Conservation Area Advisory Committee

Meeting Date : 2 October 2017

AB/11/17/HH - Extension, 77 Maltravers Street, Arundel

PROPOSED NORTH (FRONT) ELEVATION
SCALE 1:100

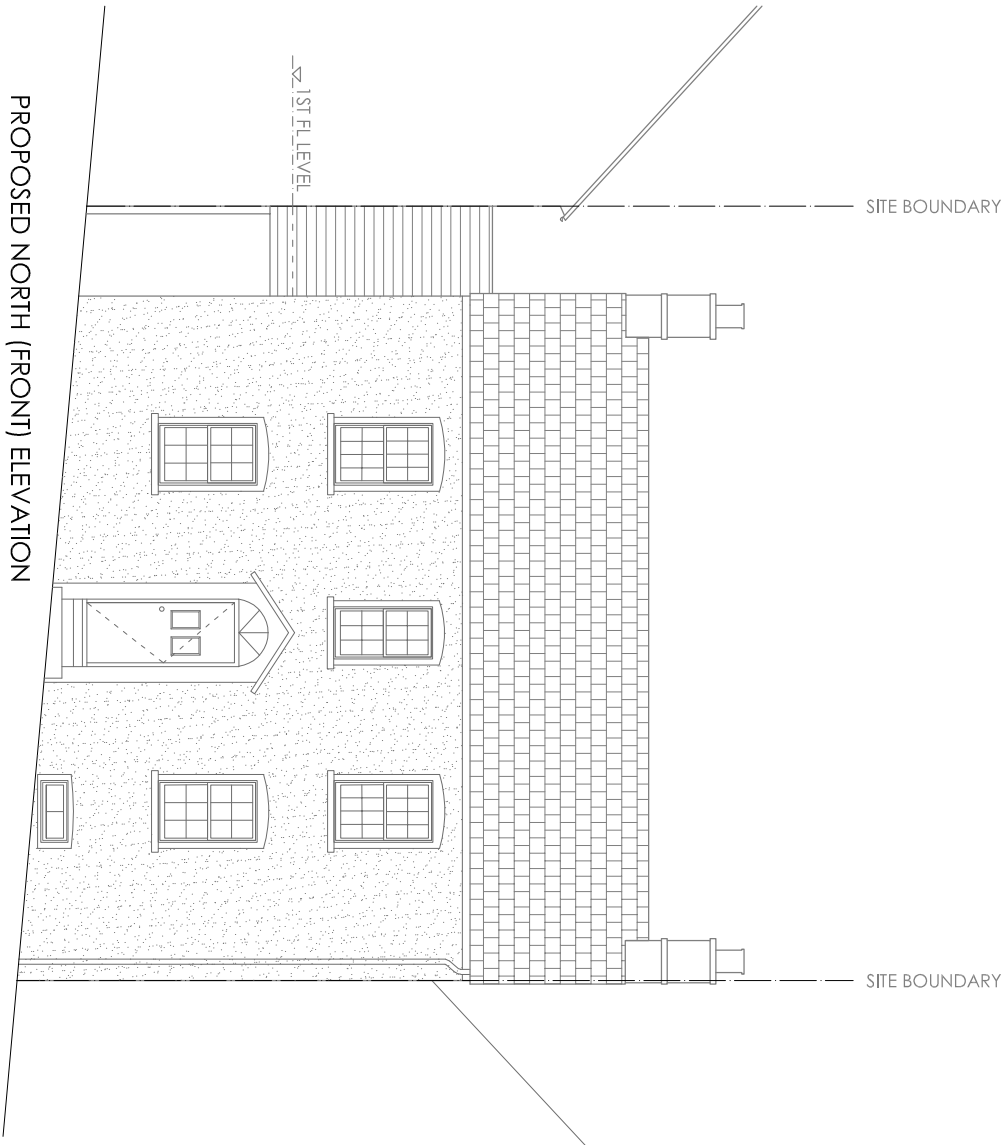
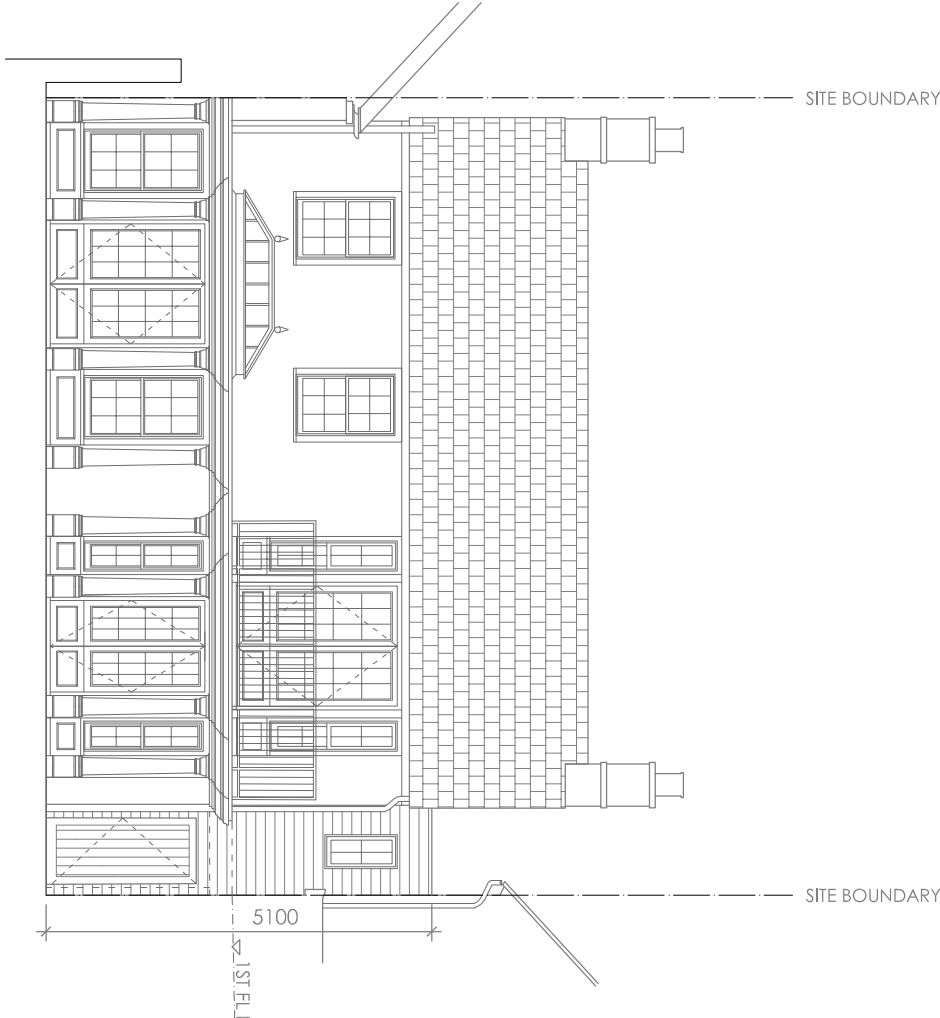
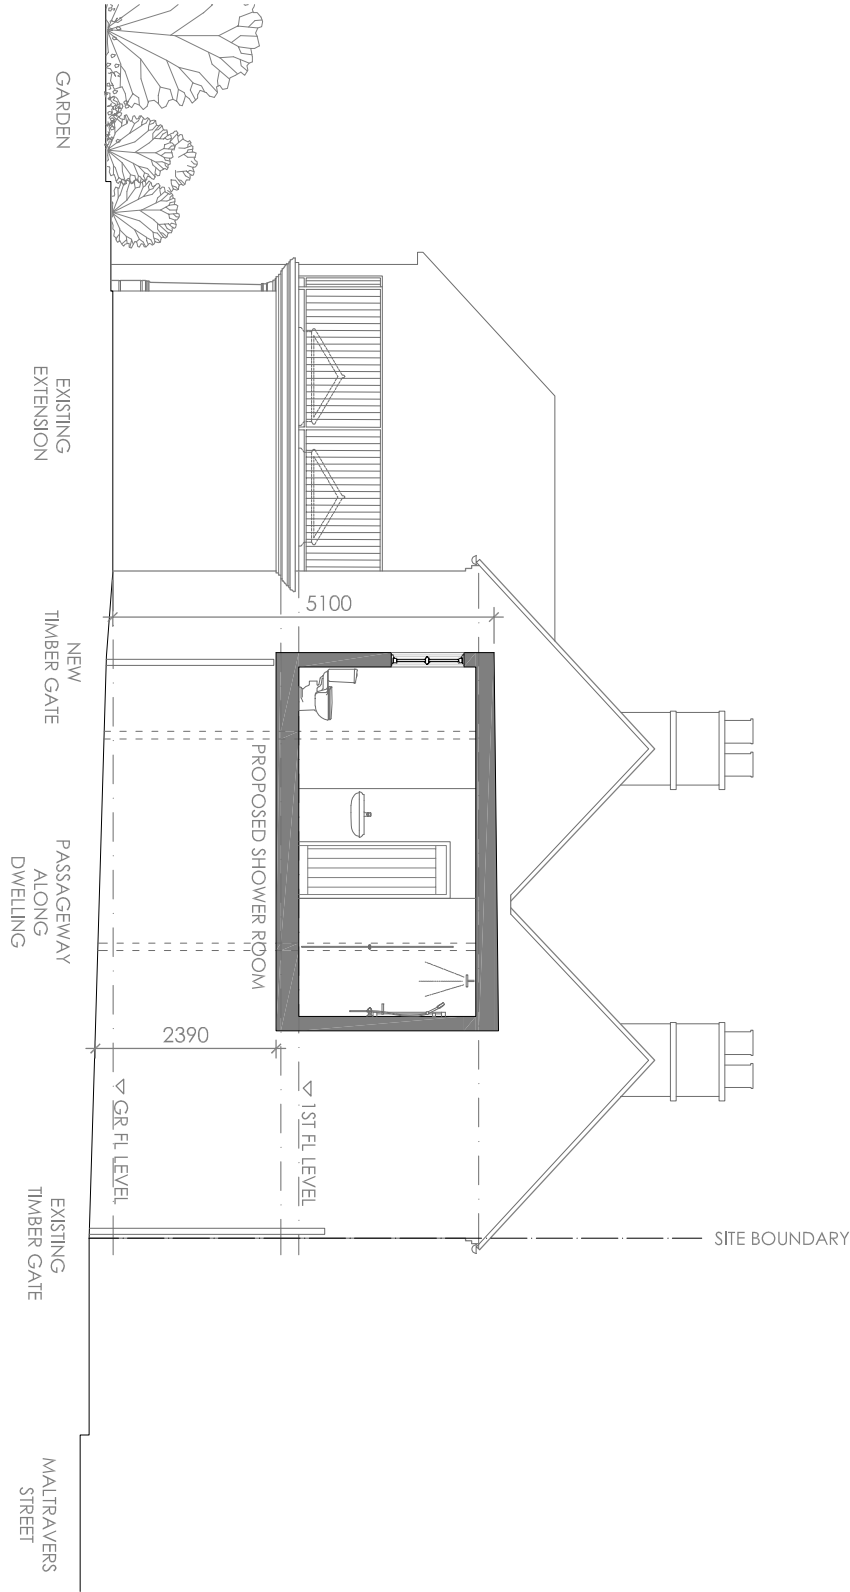
Ref	Description	Address	Design award
AB/111/17/HR	First floor side extension. This application affects the character & appearance of the Arundel Conservation Area.	77 Maltravers Street Arundel	
Comments: OBJECTION BN18 9BQ Suggested Conditions: SEE ATTACHED SHEET ALSO WE CONSIDER A SHALLOW PITCHED ROOF SHOULD BE CONSIDERED AS ALTERNATIVE TO THE FLAT ROOF, IN SYMPATHY TO THE QUALITY AND FORM OF THE EXISTING BUILDING.			
AB/112/17/L	Application for Listed Building Consent to for a first floor side extension.	77 Maltravers Street Arundel	
Comments: AS ABOVE BN18 9BQ Suggested Conditions:

Although relatively small, I am not certain that a flat roofed extension at first floor level is appropriate and may well be seen from the raised pavement opposite in Maltravers Road. Although the Agent gives limited examples of other similar extensions in the town, I am not convinced that they set a precedent.

- (1) Remove the existing, inappropriate, timber doorway and framework, located at the back of pavement and relocate it in line with the new extension above. This would re-open the gap between Nos 75 and 77, thereby improving the street scene and providing visual separation between the two buildings which differ in appearance. This would also enhance their different character and improve their setting.(Perhaps Martyn could use Google Street Scane which will show better what I mean !!)
- (2) A large scale drawing of how the top edge of the flat roof will be treated at it's north and south ends needs to be submitted as part of the application. So too should materials and finishes.
- (3) It may be better to reverse the layout of the shower/bathroom to allow the window to be installed on the north (street) elevation, in order to reduce the solid mass of the extension as seen from the street.
